WEST SUSSEX COUNTY COUNCIL CONSULTATION

TO:	Arun District Council FAO: Mr. S. Davis
FROM:	WSCC Highways - Public Rights of Way
DATE:	16 February 2022
LOCATION:	Land to Rear of Burndell Road Yapton BN18 0HR
SUBJECT:	Y/19/22/DOC Approval of details reserved by condition imposed under ref Y/89/14/PL relating to Condition No 4 - improvement of existing public rights of way.
DATE OF SITE VISIT:	n/a
RELEVANT PUBLIC RIGHTS OF WAY NUMBER(S):	FP200/2
RECOMMENDATION:	More Information
S106 CONTRIBUTION TOTAL:	n/a

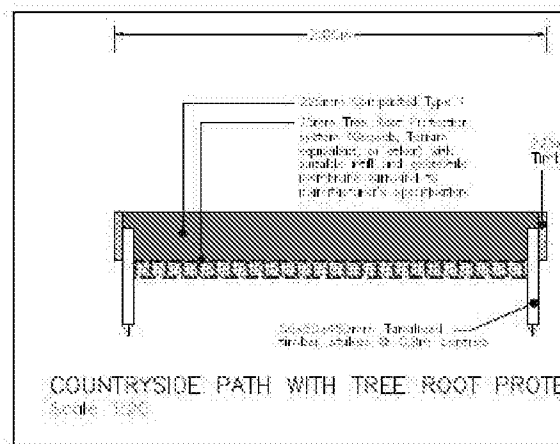
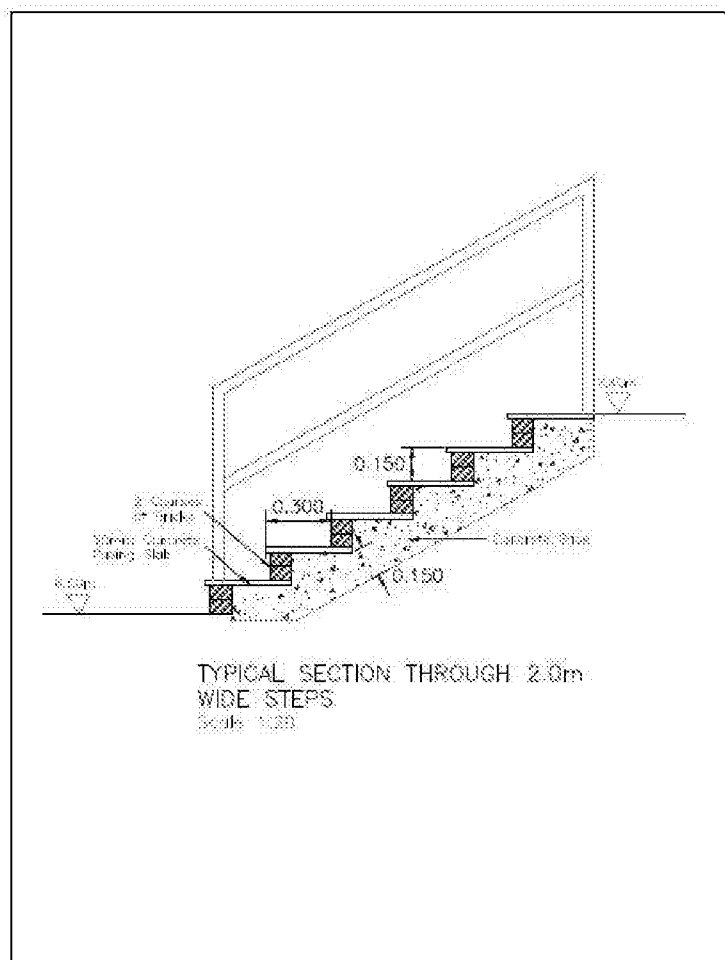
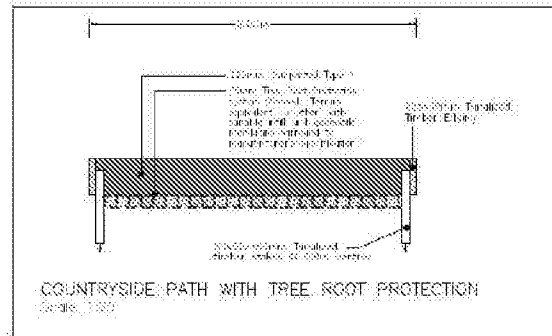
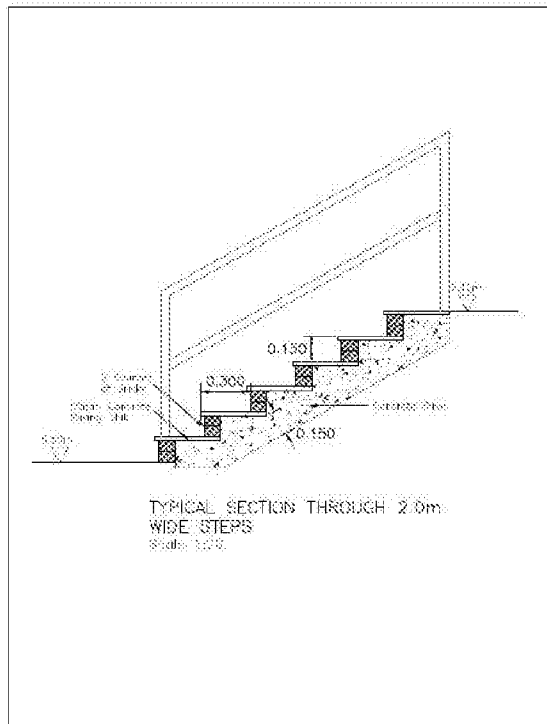
Having looked at the documents available on the LPA's planning portal there appears to be a plan showing the breakdown of the different surfaces proposed for the different sections of FP200/2 however there is no clear specification for the proposed surfacing simply references to countryside path and hoggin path. The tarmac section of this appears to form part of the footway so we have no objection to this.

In terms of the countryside and hoggin references we would need to see a clear specification showing the materials to be used to resurface the footpath and also depths in which these will be laid at and methods for compaction. This information does not appear to be available therefore would request this is submitted in a clearly understandable form for approval by WSCC's PROW team.

Further to this there appears to be a feature at the western end of the proposed resurfaced footpath where the tarmac then meets the proposed hoggin surface. This feature may suggest a road heading north and if this is the case then clarification will be needed to set out how lawful path users will be able to safely negotiate this crossing.
